Our Reference: SYD10/00815/02
DP&I Reference: MP06_0101 MOD 1 &
MP11_0093
Contact: Sevda Huseyin
Telephone: 8849 2914

**EXHIBITION OF ENVIRONMENTAL ASSESSMENTS FOR PEMULWUY MIXED USE
DEVELOPMENT, REDFERN**

DWG No. ODA013 C

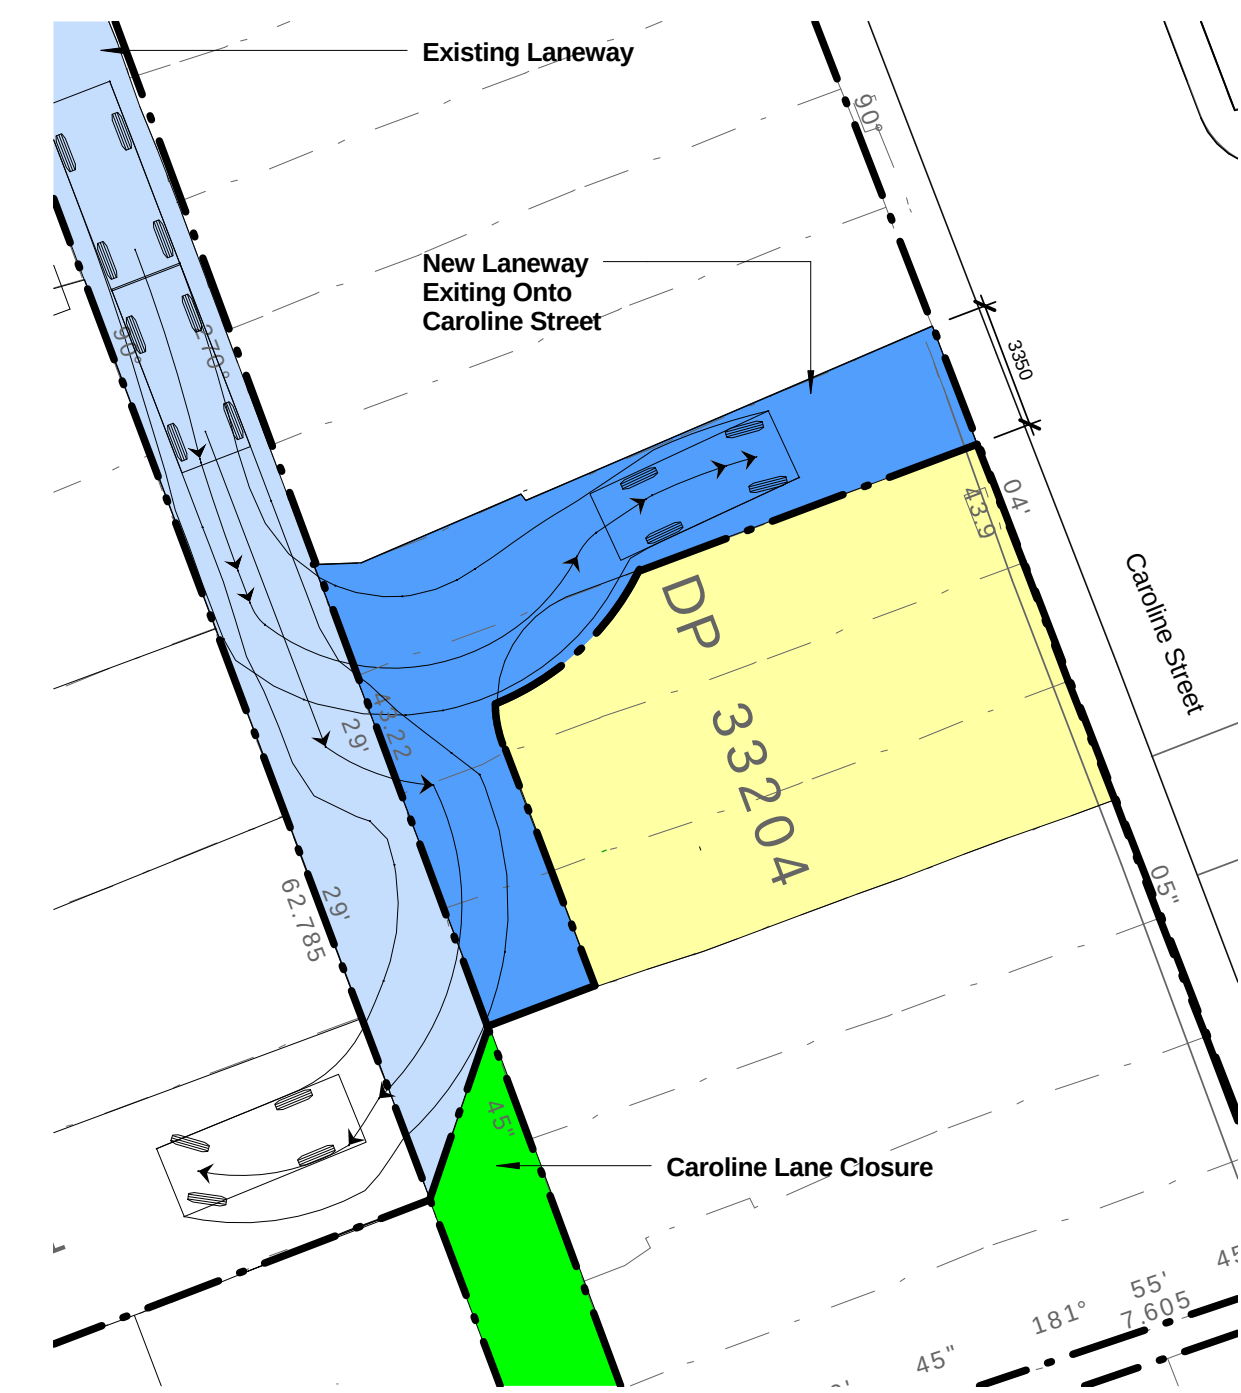
5. The swept path of the longest vehicle entering and exiting the subject site as well as manoeuvrability through the subject site shall be in accordance with Austroads.

8. The proposed turning areas are to be kept clear of any obstacles, including parked cars, at all times.
9. All vehicles are to enter and leave the subject site in a forward direction.
